Application for a non-material amendment following a grant of planning permission.

Change of use of existing ground floor retail unit (B1Business) to 3 No. flats (C3 Dwelling houses).

Reference number:	LU/45/20/PL
Date of decision	09/06/2020

Reconfiguration of fenestration to north and east elevations and omission of associated external amenity areas.

east elevation (section exiting)

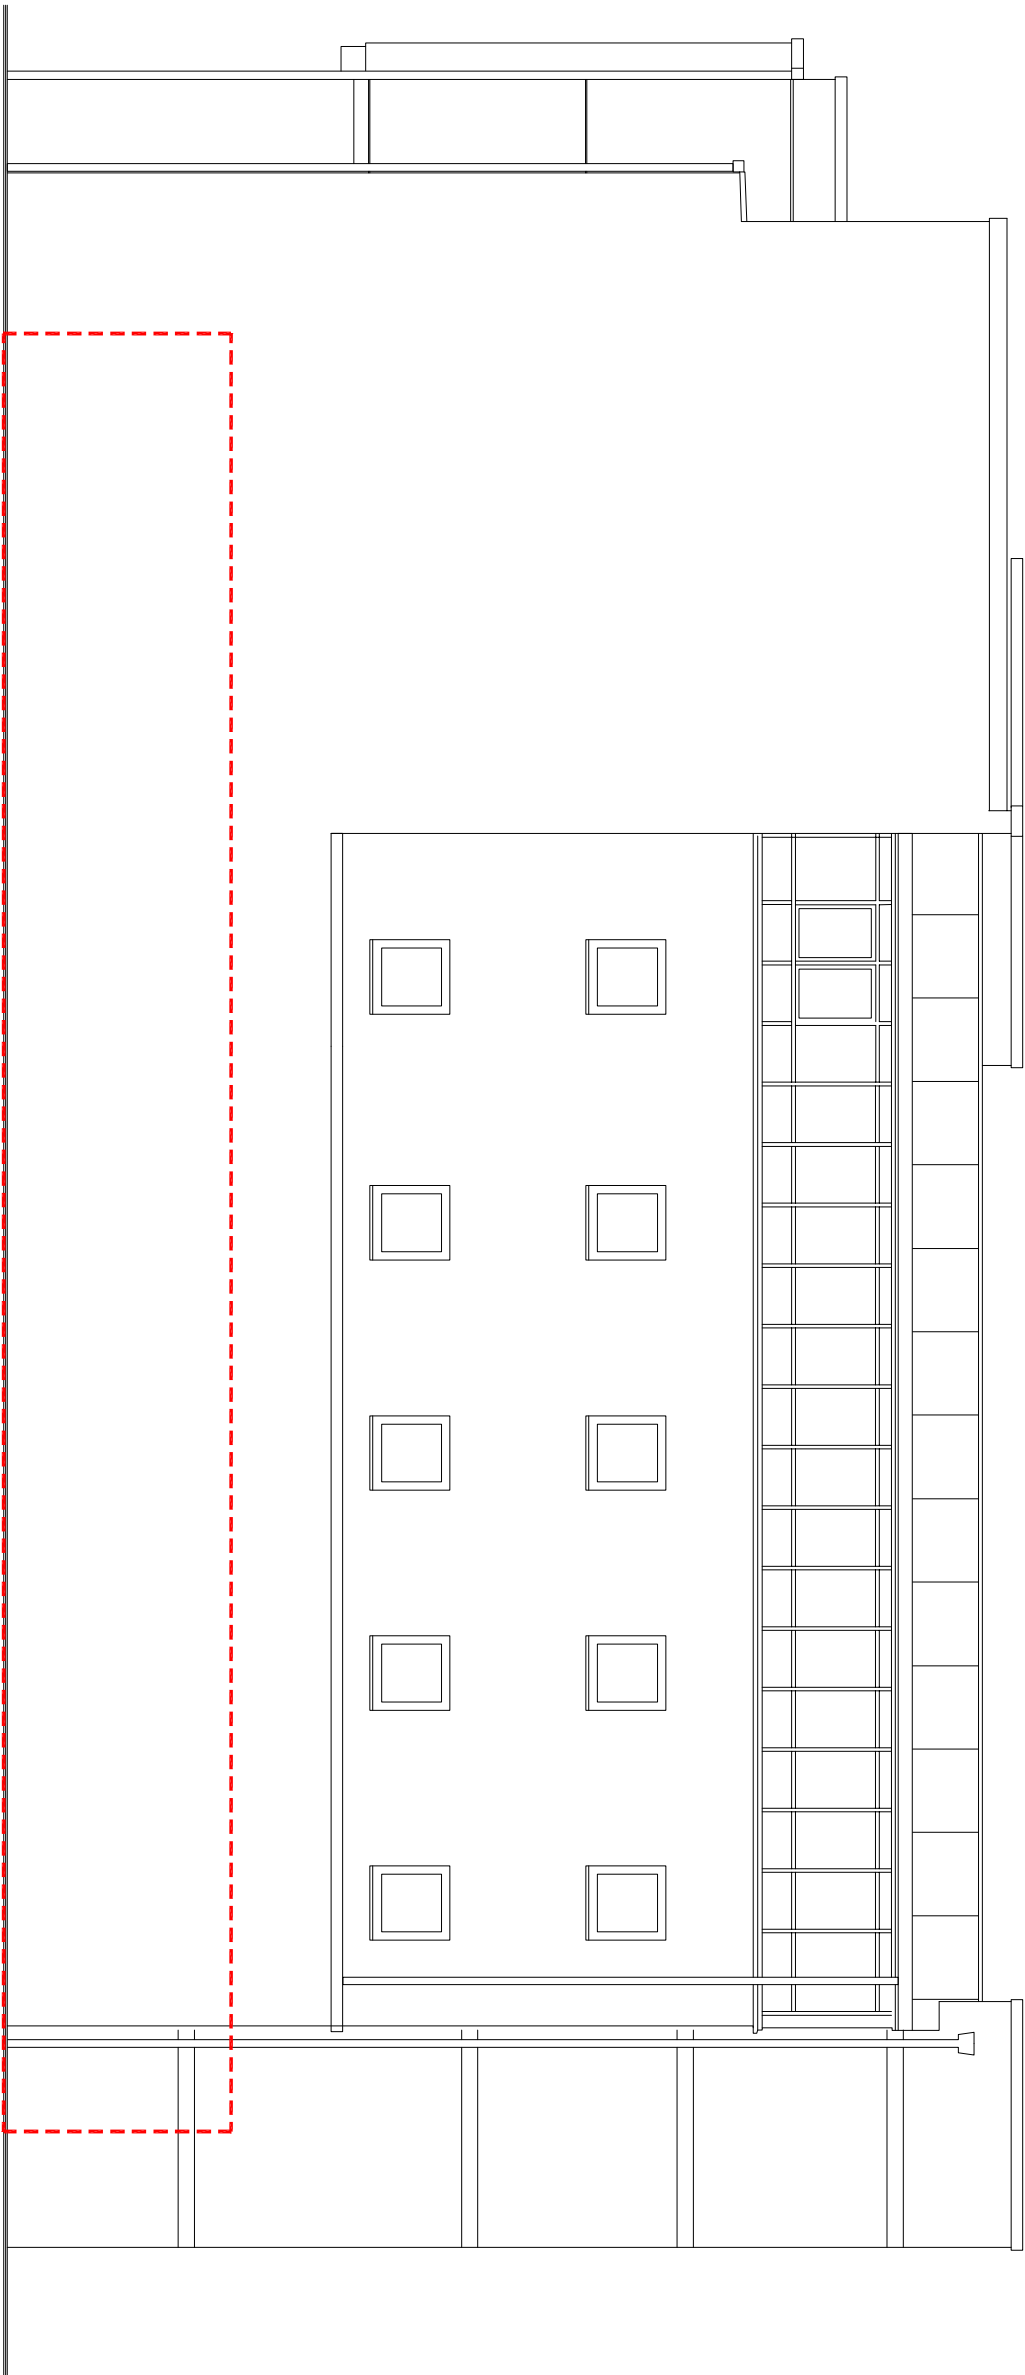
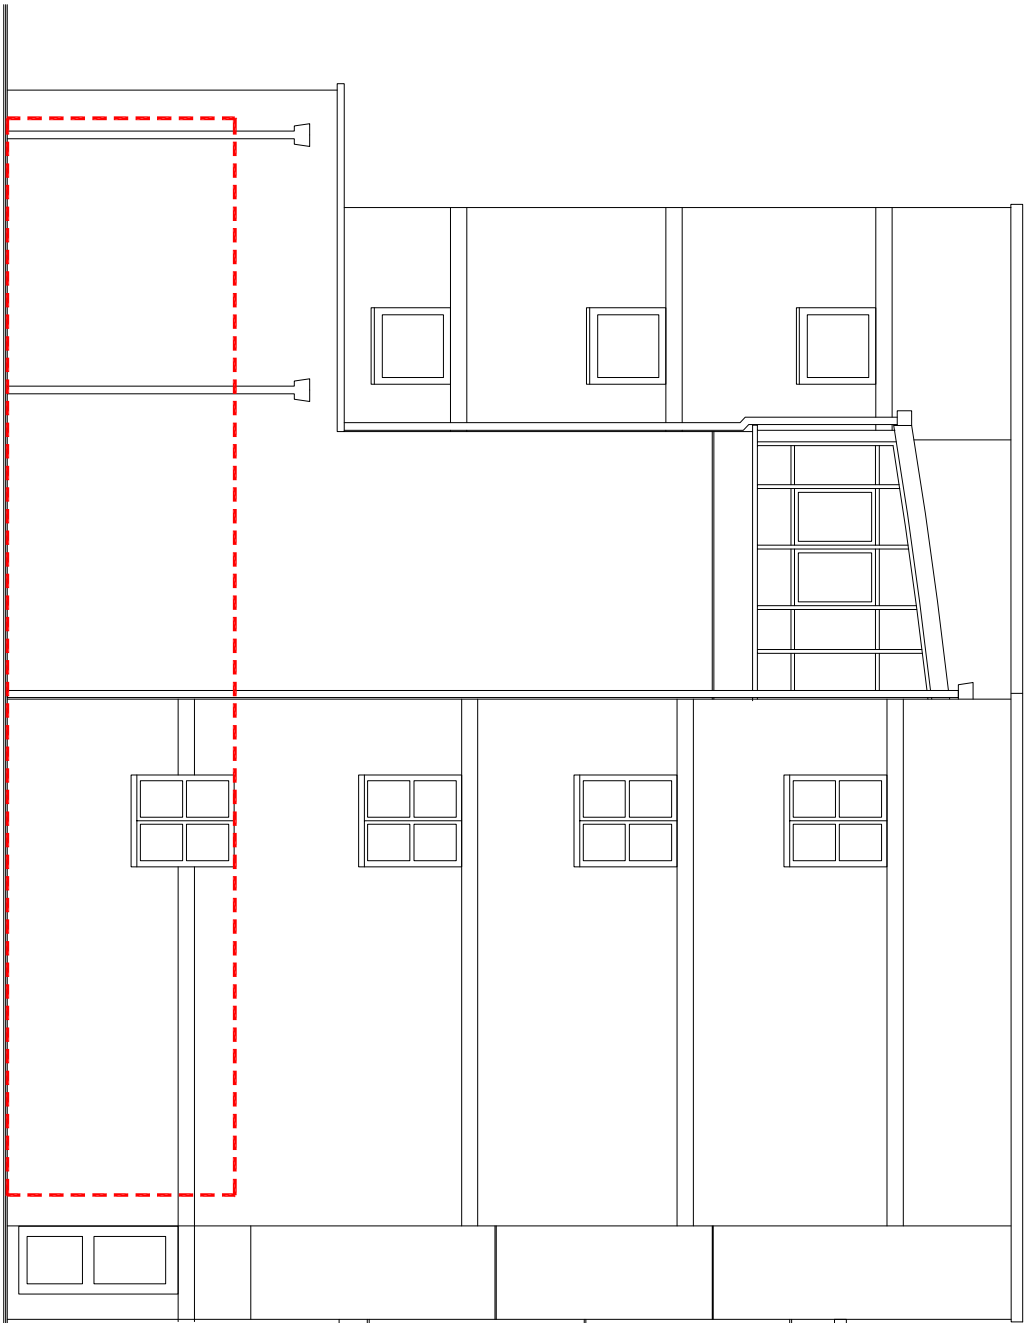
The approved plans show fenestration configuration on an existing building which did not take into account the existing services which are located on the eastern elevation. As such a non-material amendment is sought to relocate the fenestration so as not to affect the existing services (gas meter boxes/ gas pipes & electric meter boxes) and therefore not disrupt existing residents in the dwellings on the upper floors to the existing building. Likewise the north elevation fenestration showed an inset external amenity area on the back edge of footpath which would not create a desirable space for the dwelling resident and due to the beam and block floor to the existing ground floor structure would result in cold bridging issues to create such a recess which would not be practical to build.
